East Hampshire District Council

Local Impact Report

Aquind Interconnector Project

Ref: EN020022

**Plate 3.3- Preliminary Converter Station Investigation Options**

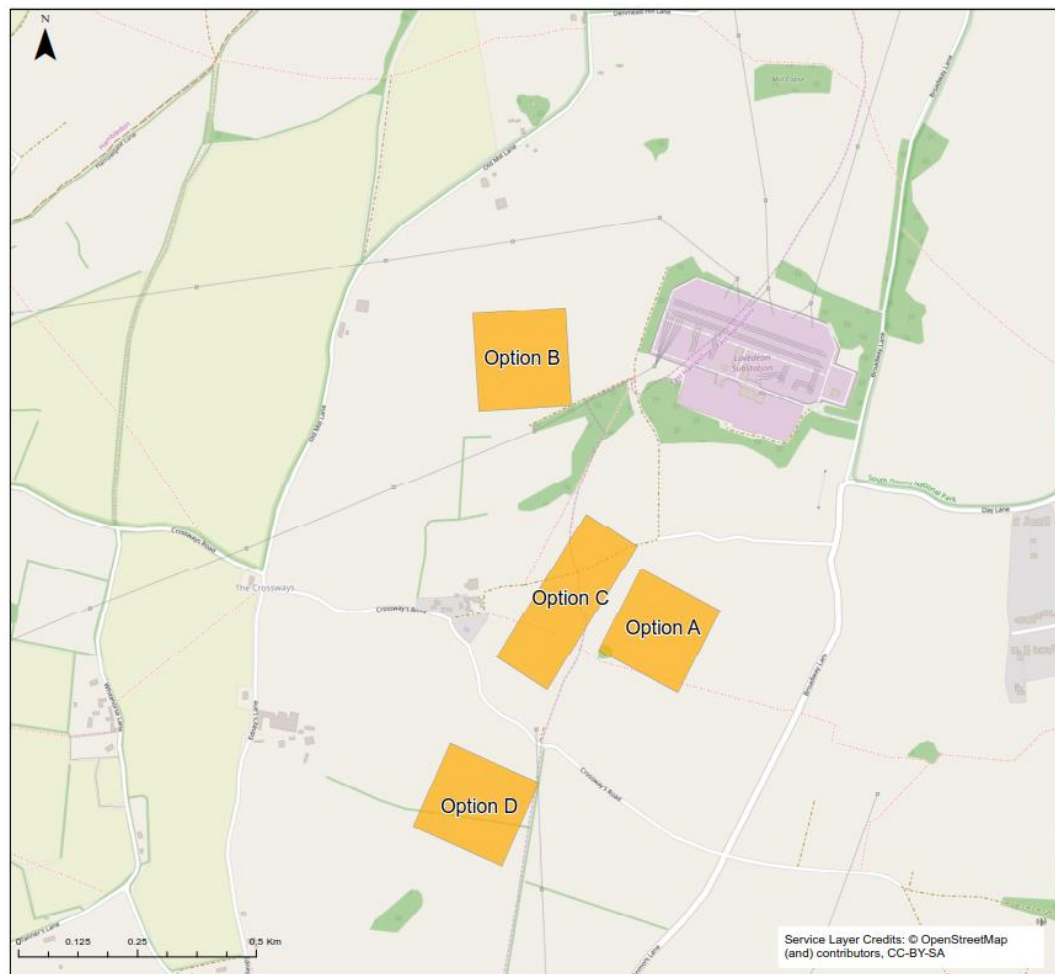
- 4.10 As outlined in the above appraisal of the sites' context, the Lovedean Substation and associated pylons in the area are prominent infrastructure features of the local landscape. Nevertheless, the local landscape is predominantly rural in character with a landscape character consistent with the landscape character assessments referred to above. Into this landscape, the Converter Station would impose a significant building(s) of a utilitarian form that are out of keeping in scale and form to this rural setting.
- 4.11 In terms of site selection, options A, B, C and D (Plate 3.3 Design and Access Statement) were discussed with the Applicant and EHDC concurs that

Option B (subject of this DCO) is the preferred option as the others are more isolated/exposed in the landscape, whereas option B is located in close proximity to the Substation and Crabdens Copse offers some established screening. There remain, however, some reservations that the initial siting exercise was limited to a 2km radius of Lovedean Substation. The reasons for this are understood (transmission losses along HVAC cables, wider cable easements etc) however, given the rural setting and the proximity of the South Downs National Park, there is concern that the setting of this designated landscape has not weighed appropriately in that process. EHDC supports the comments of the South Downs National Park Authority regarding the National Grid's duties under section 62 of the Environment Act 1995 and are not aware of any further information demonstrating that that duty has been met.

**Plate 5.5 – Indicative site layout (Option B (ii)): illustrating the location of the compound defined by the Parameter Plans and how the access to it could be arranged to preserve the ancient woodland and land ownership constraints.**

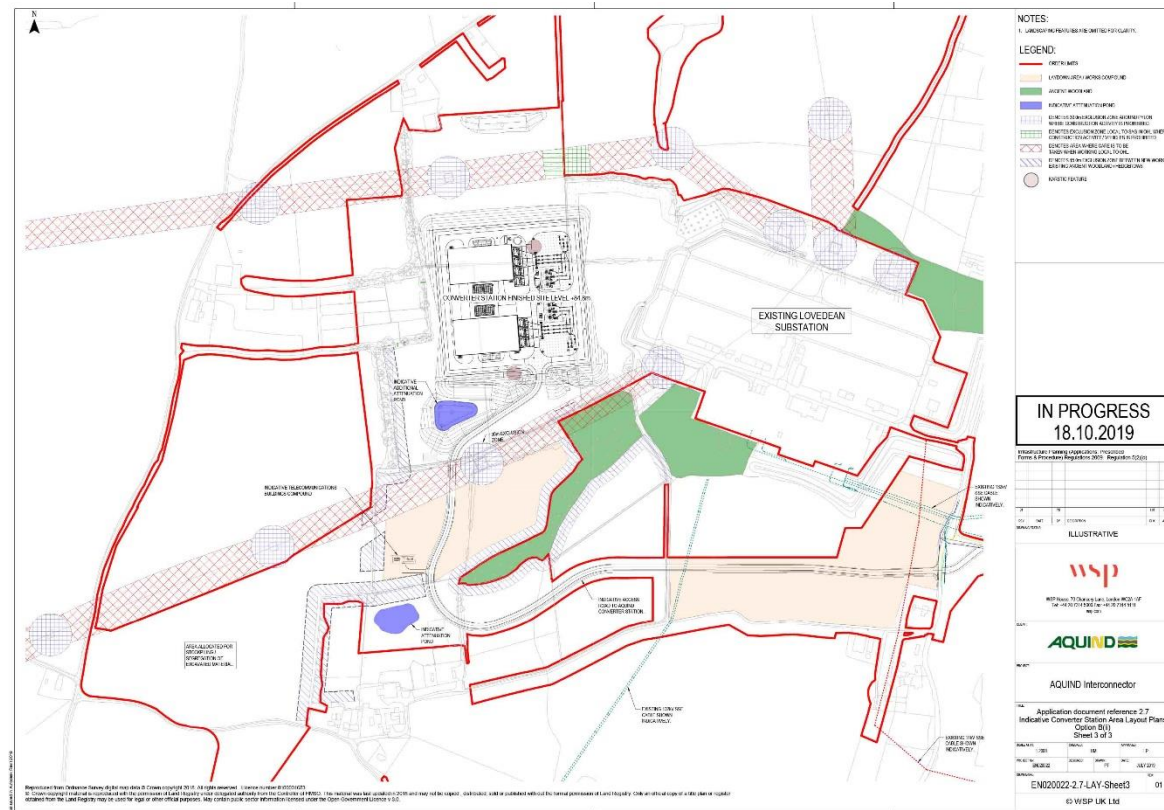
- 4.18 From a landscape perspective, there is a preference for Option B(ii) as it groups the Converter Station closer to the Substation and retains a hedgerow. Decommissioning should ensure the removal of the buildings and removal of hardsurfacing and fencing etc
